SUBMISSION AS THE LOCAL PLANNING AUTHORITY

1.1. The following information is submitted in response to the information submitted at Deadline 4 by the Applicant (National Highways) for the A46 Newark Bypass for an Order granting Development Consent. Our comments follow the Council's Local Impact Report (REP1-035), Written Representations (REP2-051), response to ExQ1 (REP2-050), comments on Deadline 2 submission documents (REP3-046), namely the Historic Environment and Visual Impact Assessment (REP2-020) and our representations at Deadline 4 REP4-045 (Written summaries from the hearings) and REP4-046, 047 and 048 (Responses to further information).

1.2. The comments made for Deadline 5 are made by Newark and Sherwood District Council in their statutory role as the Local Planning Authority (LPA) and not as landowner. Newark and Sherwood District Council, in their landowner responsibility will not be making any comments for this deadline and it is understood that discussions on land acquisitions are still ongoing.

**Viewpoint 24: View north from Sandhills Park representative of views for residents.**

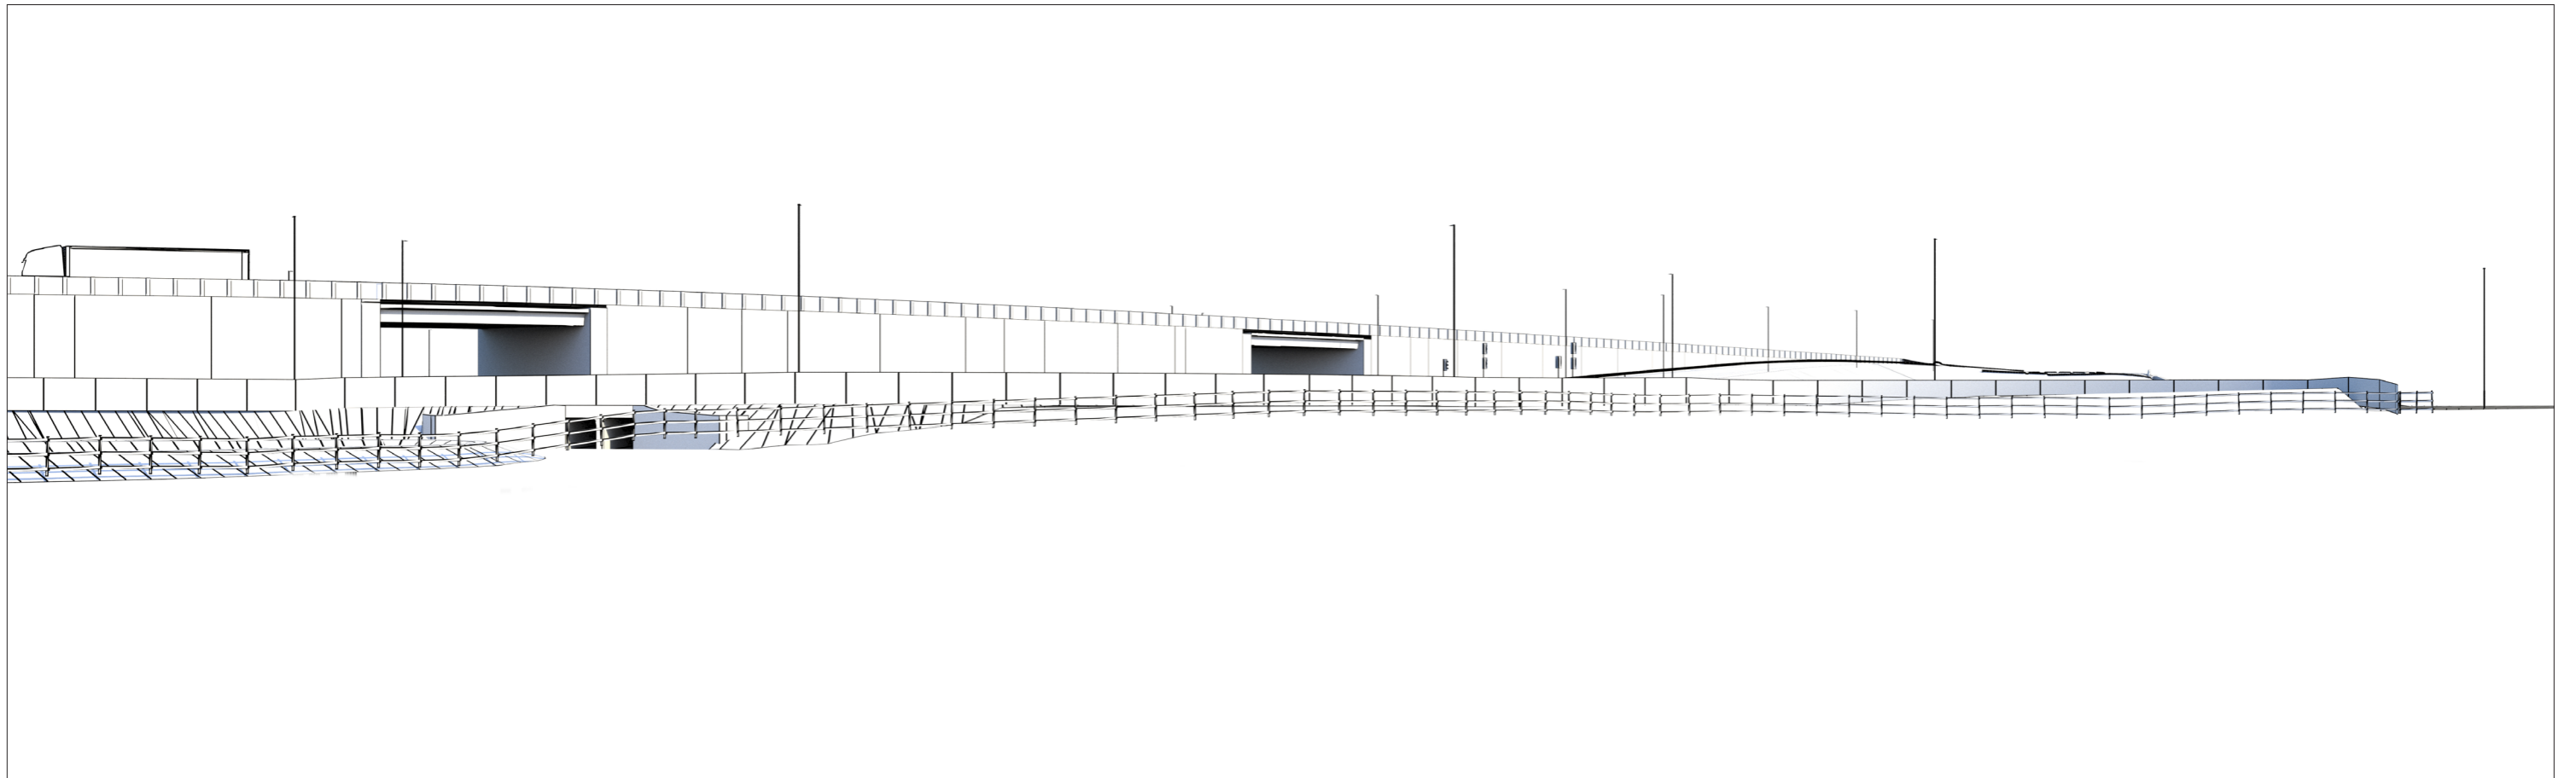
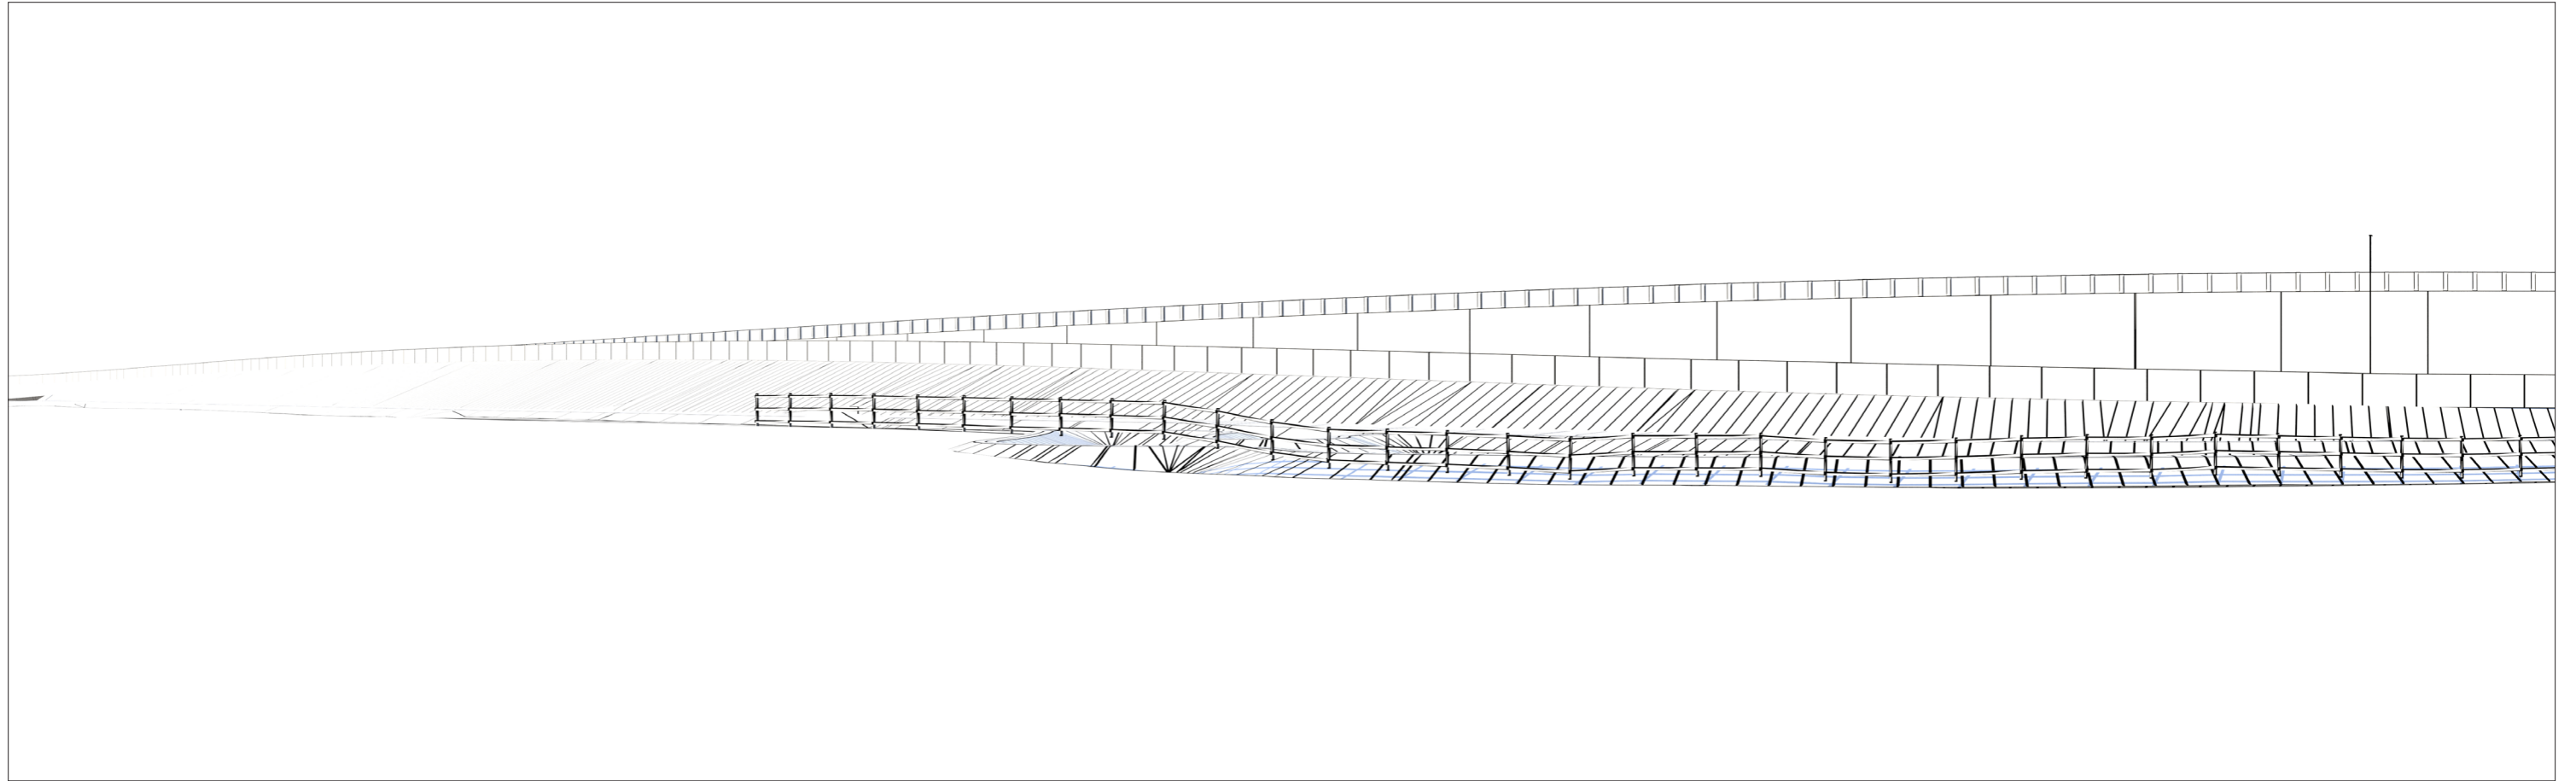
Action No.3 – additional wireframe at Viewpoint 24

2.12. The wireframe produced would seem acceptable to the LPA as an accurate representation, without evidence to the contrary from us to corroborate this. The absence of vegetation or mitigation planting allows us to see the full extent of the structure as proposed, accepting that this is not its fully designed out form.

2.13. The wireframe was produced from the first floor bedroom window of no.2 Sandhills Close which shows the visual impact at a higher level. Whilst this does not show any intervening features in the landscape it shows almost a worse

case for the occupiers at that property. However the Council's concern as the LPA would also consider that the impact within gardens (no.22-27 Sandhills Close) would be the most severe given the increased elevations and this would be most acute through noise the oppressive nature of the infrastructure. AS-026 shows the Environmental Masterplan for the Scheme which we don't believe has been changed since the first submission. Whilst NSDC understands that the need for drainage for the Scheme and that planting cannot be provided for on existing bunding there to protect existing residents from flooding, why can the 'wet area' illustrated below, not be located further south-west so additional tree planting or denser block planting of trees (which are shown to be able to be planted in this area), not be clustered together to create a woodland effect of two rows of trees. We appreciate that the Applicant has previously stated that the planting scheme has been maximised to the constraints available however we can only see this option being suitable to improve the outlook for residents which is in the control of the DCO Scheme.

**Viewpoint 25: View south from Great North Road (A616) representative of views for road users**

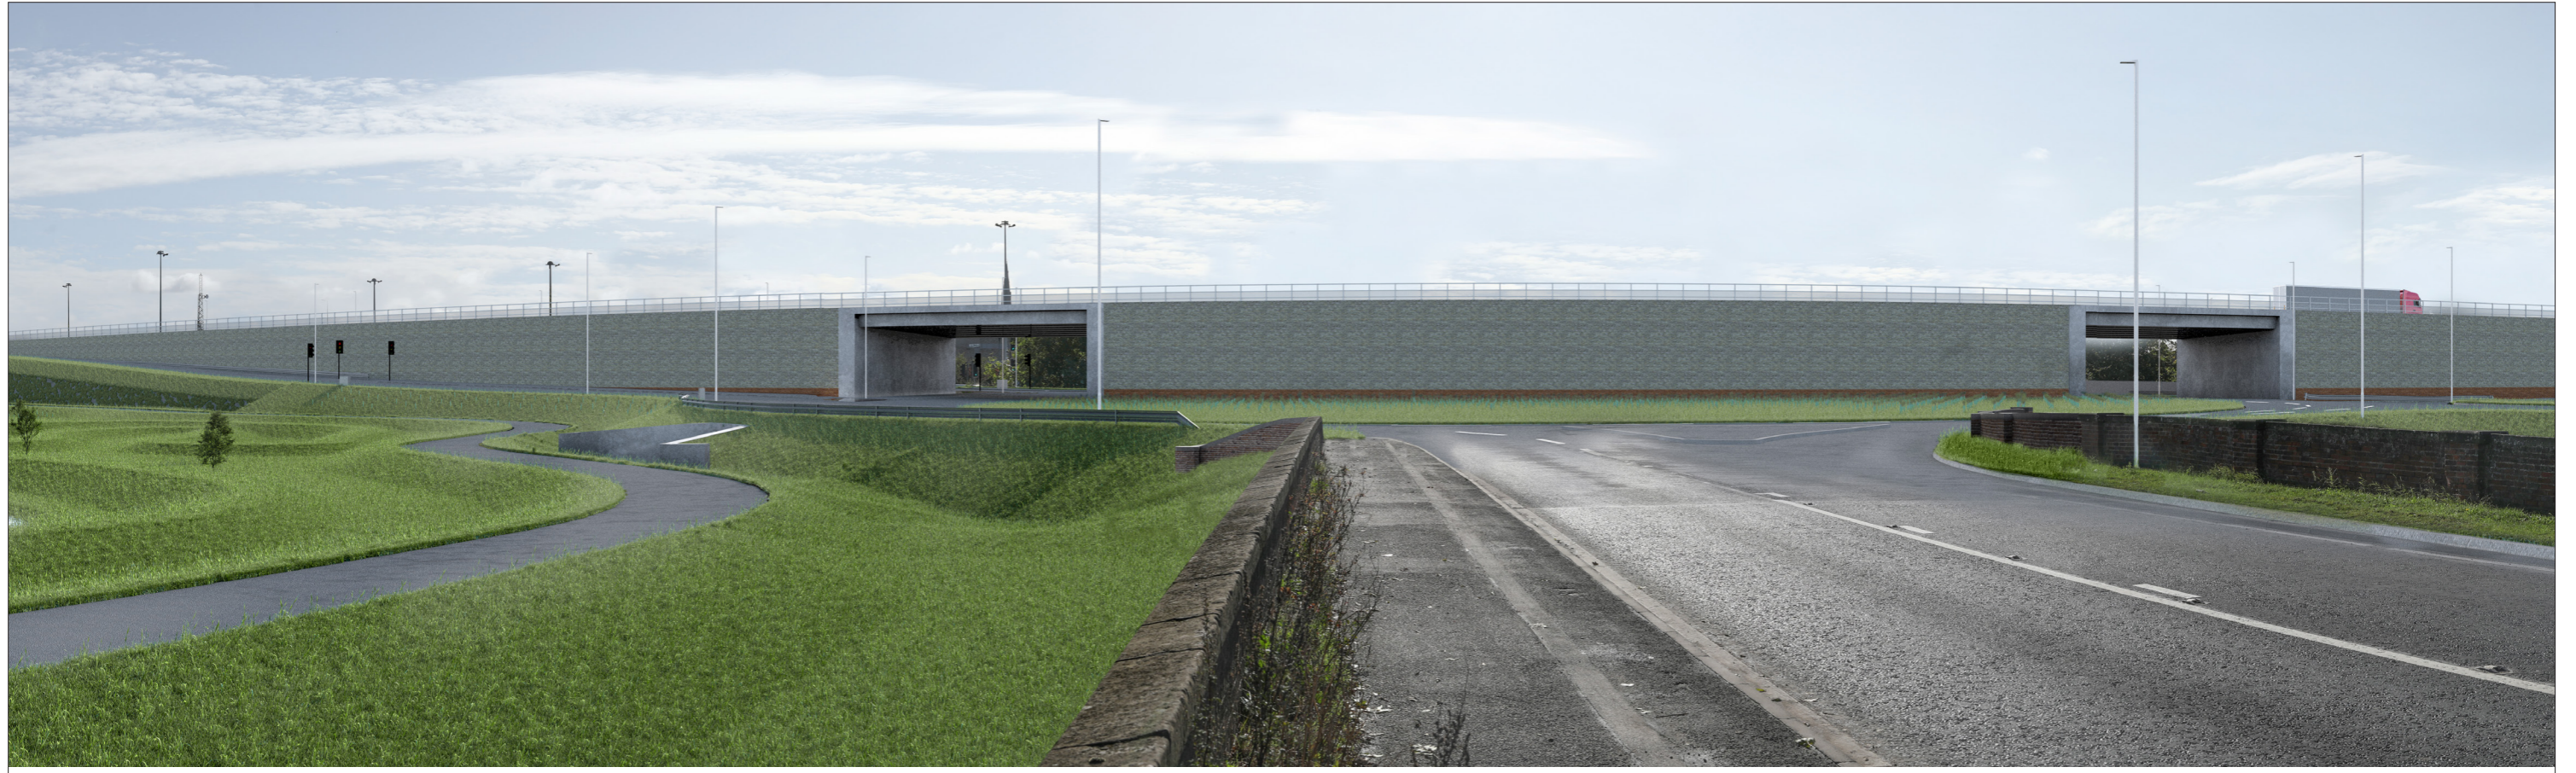
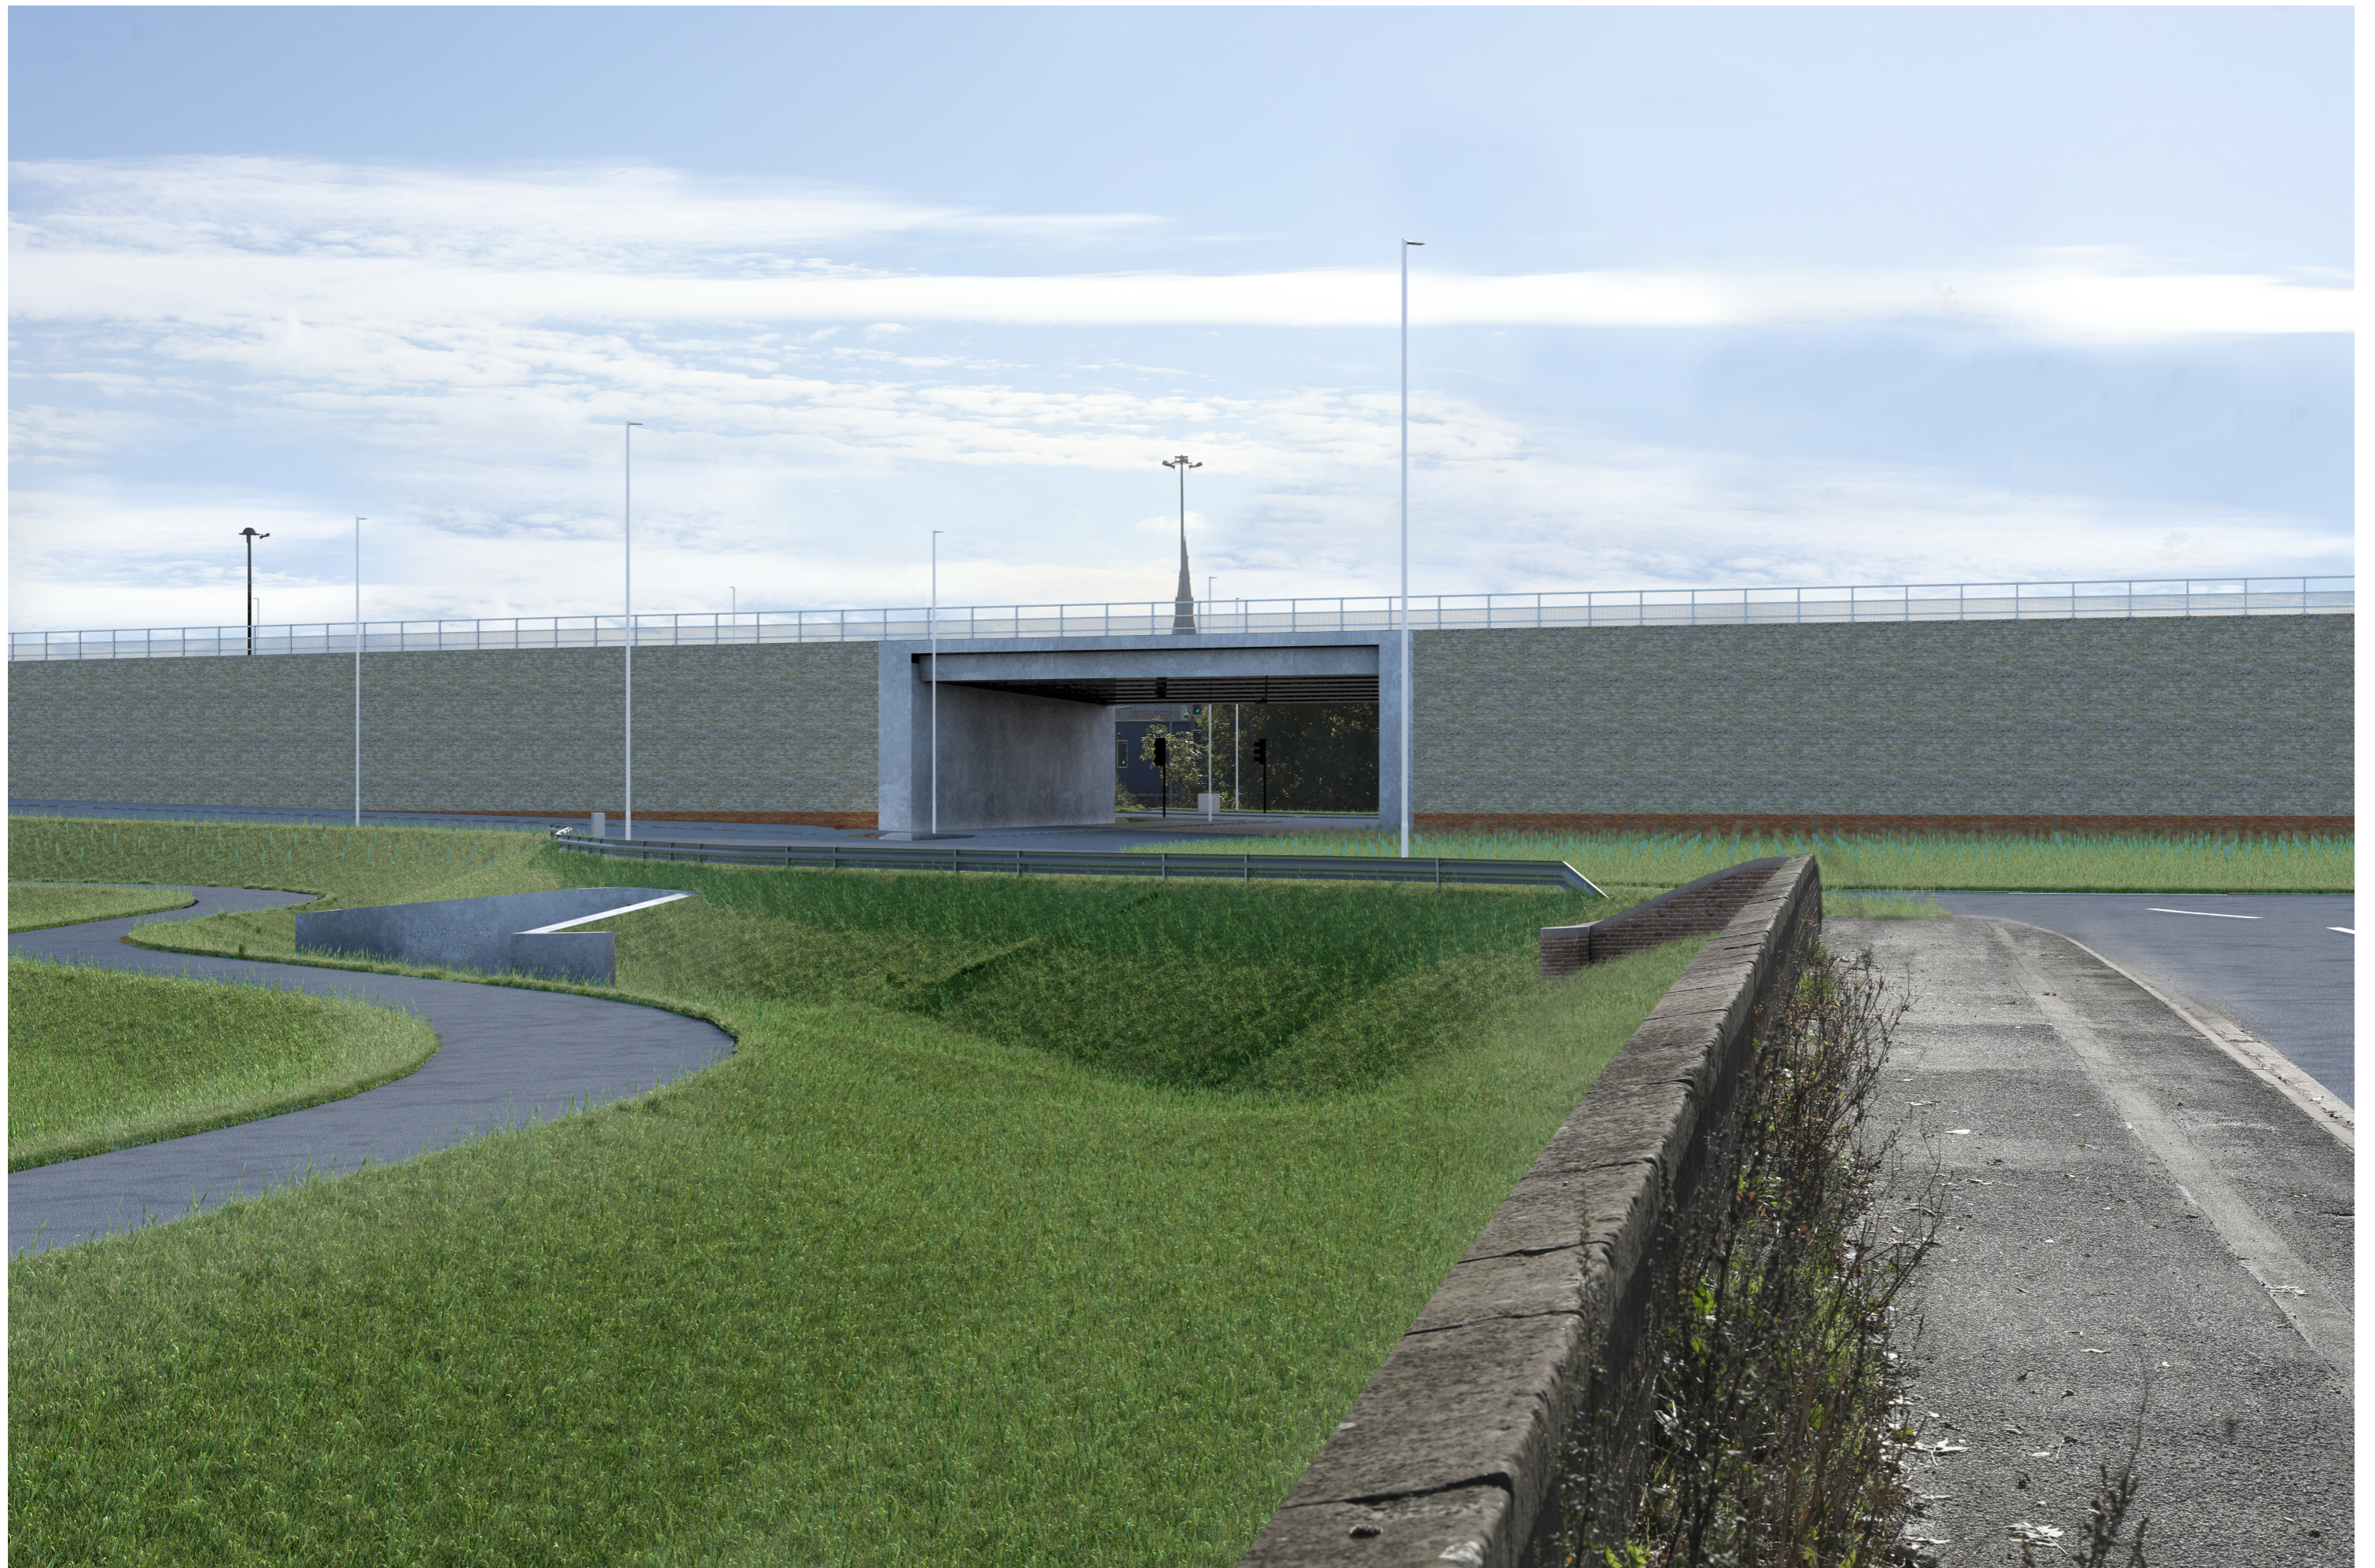
- 2.10.** The update to Viewpoint 25 to show the amended layout to Smeaton's Arches is welcomed and we have no further comments to make on this point.

2.14. Turning now to the Smeaton's Arches approach, south on the A616. It is accepted that the viewpoint and visual representation is most likely not taken at the most appropriate position in order to illustrate how the Scheme would make use of the existing vegetation. Instead a position further north-west would have shown the bank

of trees, outside of the Order limits, being retained. However, we were fully aware of this area remaining when we have raised our previous comments, and it has therefore not been ignored. Our main concern, as reiterated previously, has been the land adjacent to the highway and around the edges of the roundabout. The applicant has stated that the scheme has been designed in full accordance with the information within LD117 (version 0.1.0) which is a National Highways document for the design manual for roads and bridges. However, at its heart this document states that *Integration and minimising the impact of disturbance of new roads within the rural or urban landscapes and improving the landscape character of existing roads is the basis for good environmental landscape design*. Stated within this document are the principles and purpose to the design which includes enhancing and improving the landscape quality and environment and creating opportunities to conserve and enhance the landscape character. In addition it states that excellence in landscape design should also be inclusive in respect of places, people's needs and **views**. Within this document also it states that designs should take account of the maintenance, management and operational requirements where shrubs are planted within 4.5m of the edge of carriageway, medium sized trees no closer than 7m (girth less than 450mm) and climax trees (girth greater than 600mm) not within 9m, **unless otherwise agreed by the Overseeing Organisation** (para 3.4.1) (emphasis added). Who is this Overseeing Organisation and if they can override the document then this must be for valid reasoning. In our opinion additional planting adjoining the A616 is necessary to frame those views on the approach to the Cattlemarket roundabout, even despite the trees remaining beyond the Order limits.
